Householder Application for Planning Permission for works or extension to a dwelling and for relevant demolition of an unlisted building in a conservation area
Town and Country Planning Act 1990

An existing rear dormer is being repositioned to line up with an existing internal staircase and window below to allow for a new access to the existing loft area.

title Planning Proposed Plan
& Rear Elevation

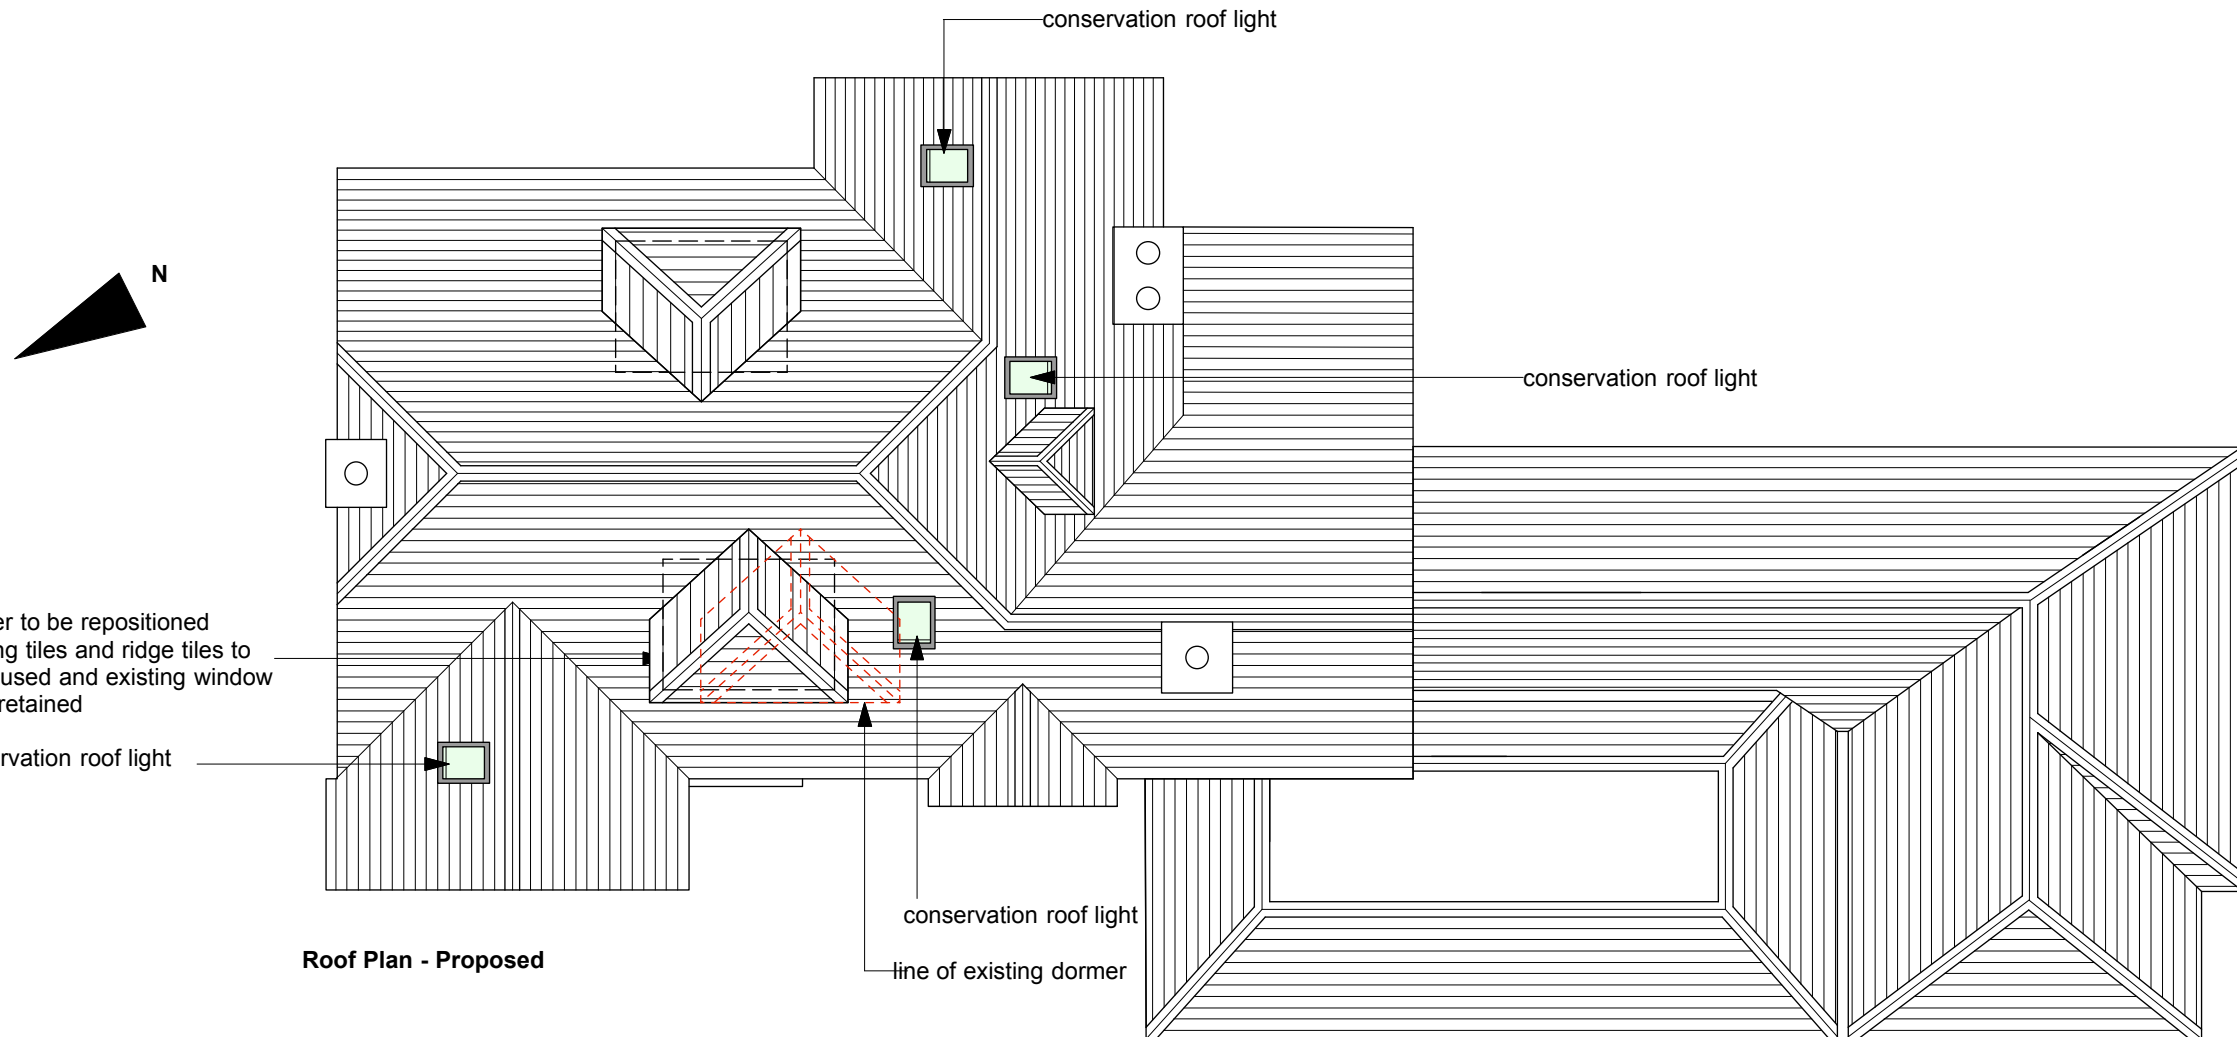
The proposed rear dormer will replace an existing dormer at approximately the same location, with the same design and size. Whilst the dormer appears to be approximately 0.1m wider, this increase is marginal and would not create any harm. In addition, the alterations will take place to the rear and will not be visible from the street. This element is policy compliant in terms of its size and siting, therefore acceptable.

The number of proposed rooflights on the roof slope appear to clutter the roof and should be reduced in number. The single roof light on the side roof slope will be acceptable. However, the 4no. roof lights on the rear roof slope should be reduced to 2no. It is advised that 1no. roof light adjacent to the rear dormer and 1no. roof light on the pitched roof of the rear projection will be acceptable.

With regards to materials, the alterations to the rear dormer should match the existing dormer and should be replaced like for like. In addition, the proposed rooflight should be 'conservation type' and should be of timber and glazing.
